**NEW PRIMARY SCHOOL IN EDMONDSON PARK
BUCHAN AVENUE, EDMONDSON PARK, NSW 2174
DESIGN BCA COMPLIANCE REVIEW (SSDA DESIGN STAGE)**

SCHEMATIC DESIGN BCA COMPLIANCE REVIEW

PROJECT NO.	GDL 210133
Property Details	New Primary School in Edmondson Park
Client	Richard Crookes Construction Pty Ltd
Date	18.05.2021

The following Schematic Architectural Drawings (Issue for Coordination) prepared by TKD Architects Pty Ltd, dated 29.04.2021, was reviewed as part of this assessment:

Drawing No. **AR W- DW- 2100 J**

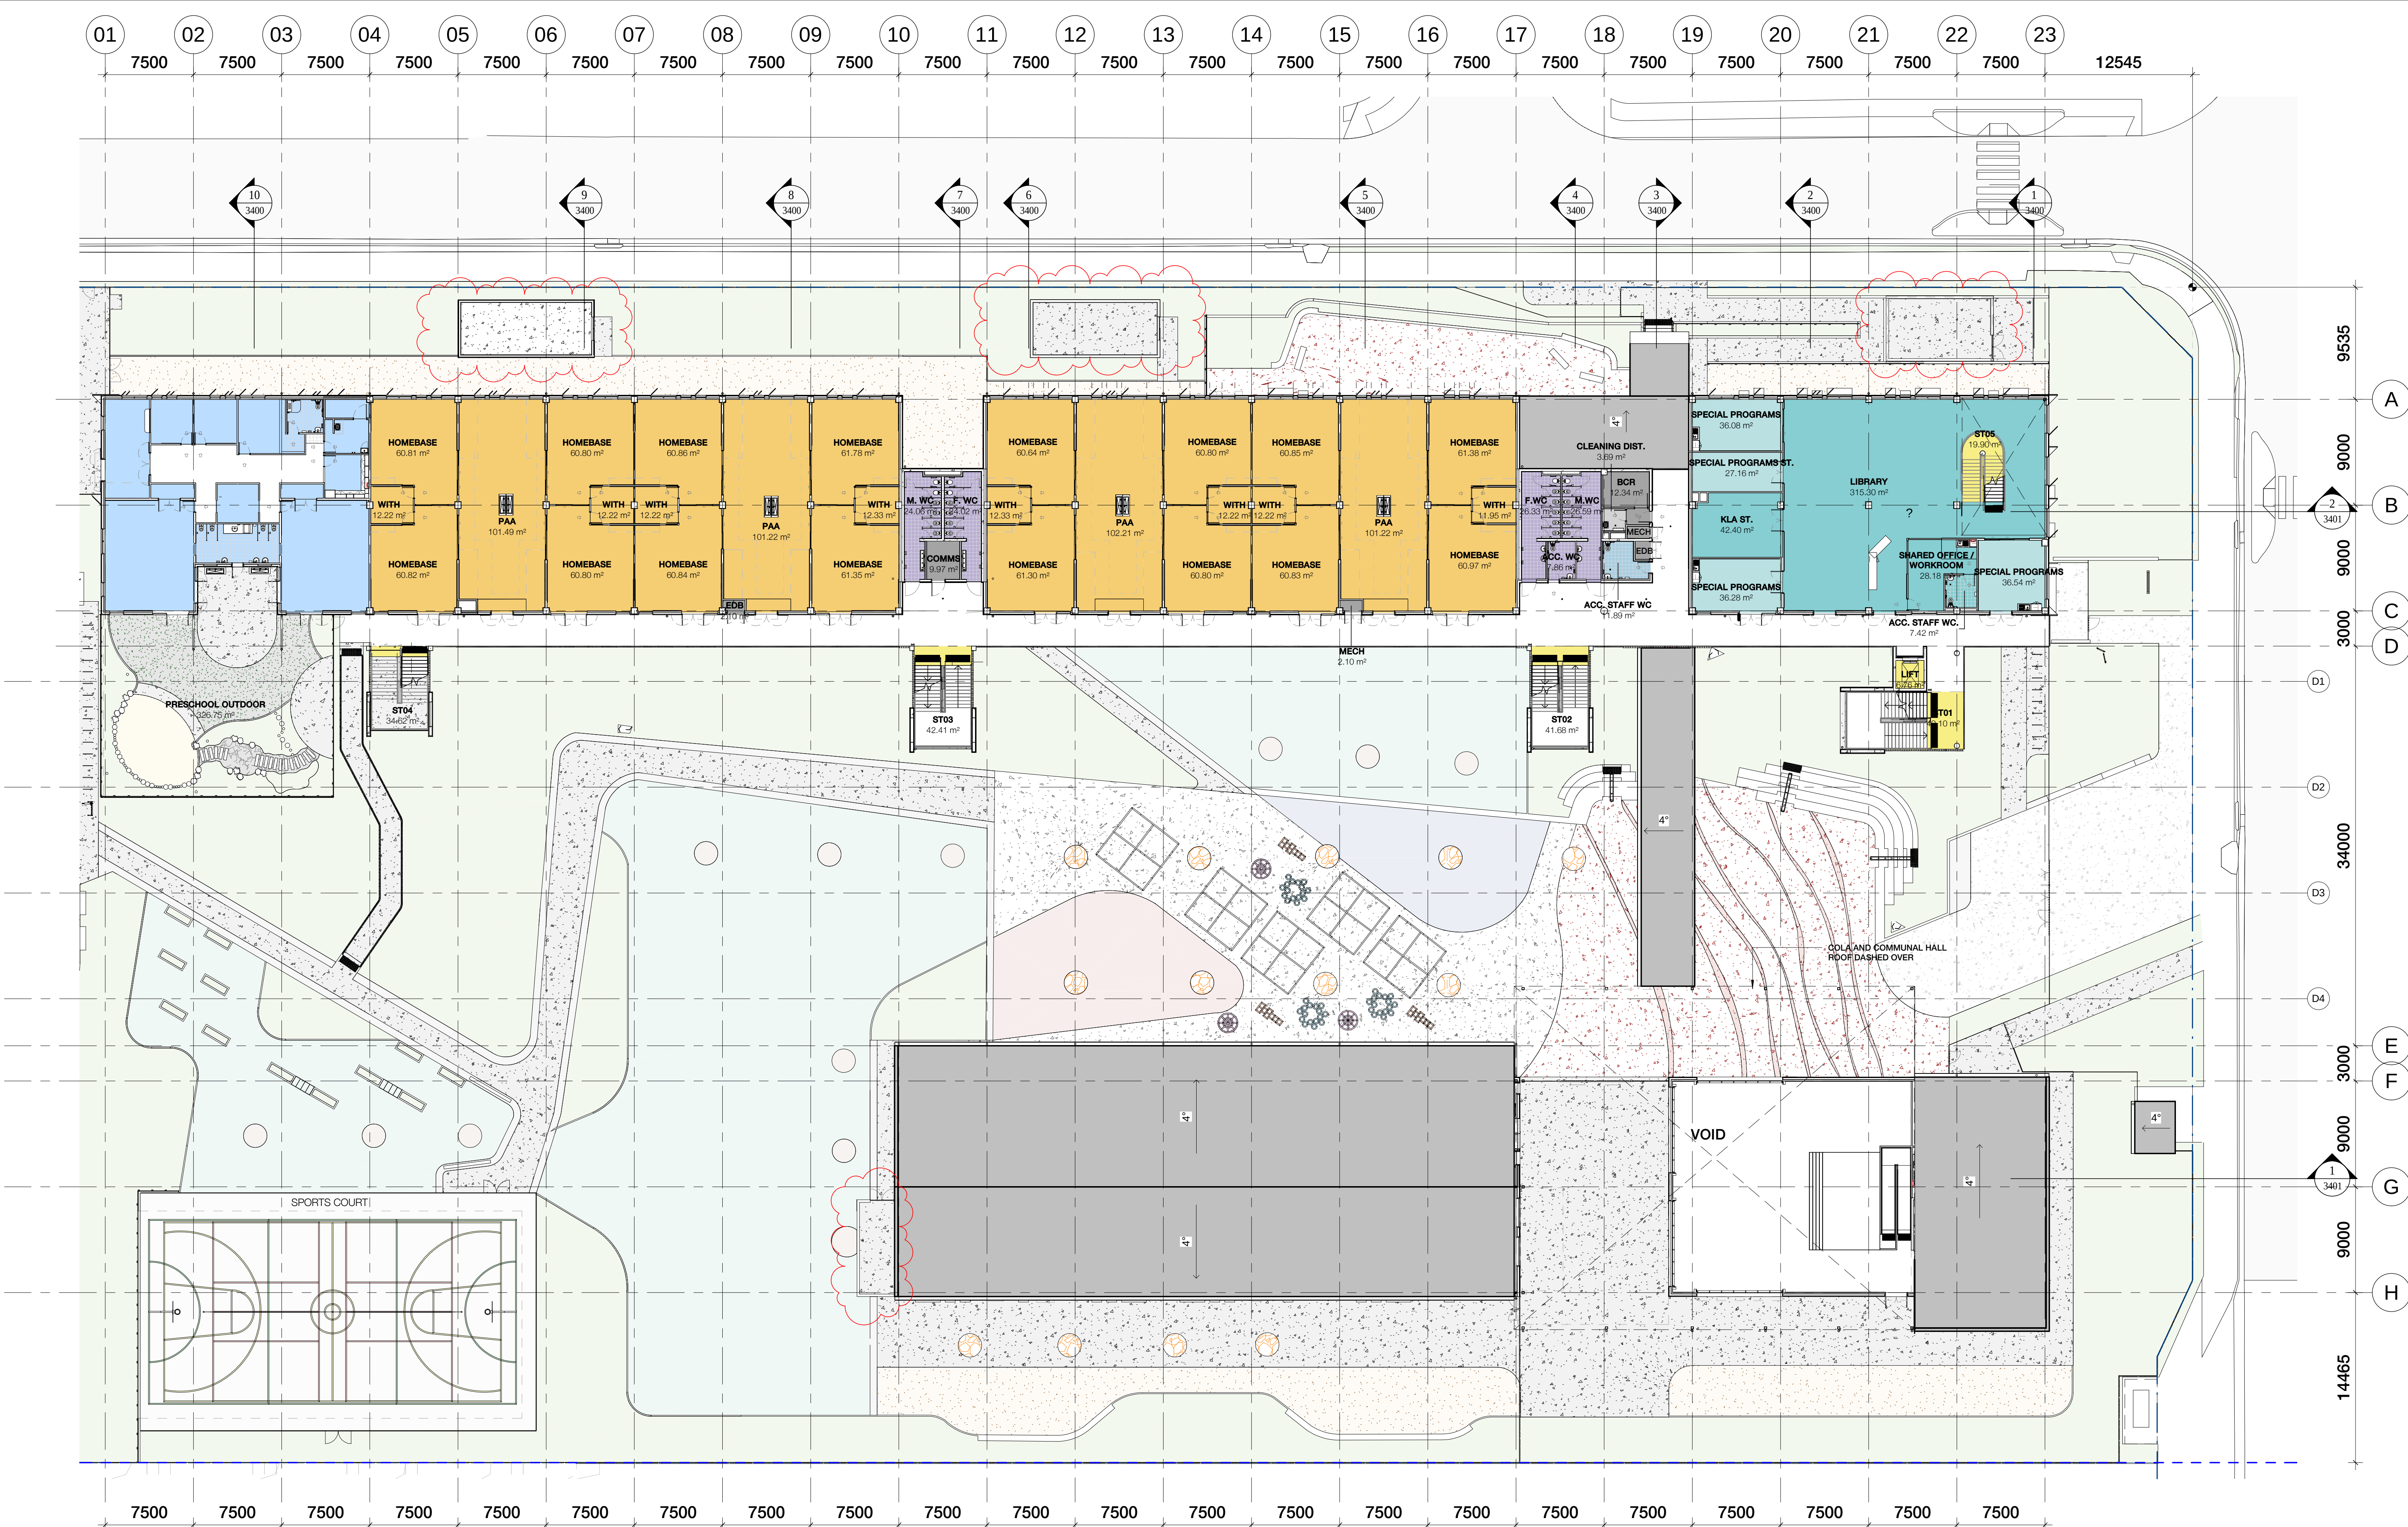
7.	Extended travel distances to an exit of more than 20m to point of choice and more than 40m to closest exit (approx. 44m)	More Detail of doors internally, egress paths, and layout to be provided, however even with this travel distances with the current location of stairs may not be achievable via DTS compliance.	D1.4, D1.5	DP4, EP2.2	TBC

9.	Discharge of exit to open space must not pass under the/other building (bridges overhead, re-entry) before reaching road / open space	Architect to confirm, this is to ensure there is an egress path other than that which needs to pass under the covered walkway or any other roof feature. As Exits must reach an open to the sky area and not pass under a roof structure again until the public road is reached for BCA compliance to be achieved.	D1.7	DP4	TBC

The external stairs are interconnecting 3 storeys and located closer than 6m (4m approx.) from the external walls, thus additional protection in accordance with Clause D1.8 will be necessary, or the stairs are to be pushed away from the building further to achieve compliance.

<ul style="list-style-type: none"> Non-fire isolated stairs must provide a stairway discharge to a point of not more than: <ul style="list-style-type: none"> 20m to an exit 40m to one of 2 exits <p>From the information provided, the travel distances are able to comply except a Level 1 Library (marked in red). Please see mark ups with the most critical travel distances in Appendix B at the back of this report.</p> <p>Note: There are numerous areas where the BCA point of choice is located inside the classrooms, so exit signage, door latching and provision of exit doors will need to be detailed to ensure compliance is provided.</p> <p>BCA compliance is achievable, but redesign as the detailed design progresses will be required to avoid Fire Safety engineering.</p>
D1.6	<p>Dimensions of Exits and Paths of Travel</p> <ul style="list-style-type: none"> Required egress paths of travel to an exit must be provided with at least 1m clear width and 2m height. Doorways to have at least 850mm clear width and 1980mm height (accessibility purposes that requires 850mm opening plus circulation spaces). Aggregate exit width is to be calculated according to occupancy number from Clause D1.13. See this clause below as we need Population Numbers to determine compliance. Generally, 1m exit width (stair width) can accommodate egress up to 100 people, thus the stairs with 2m width (or more) must be provided with additional handrails where additional aggregated egress width is needed. <p>Levels 1 and 2 are served by 4 external stairs of 2m width approximately each, therefore each stair can accommodate up to 200 people which is considered sufficient. Operator to provide number of occupants (Clause D1.13) in order to confirm this assumption.</p> <p>BCA compliance is achievable.</p>
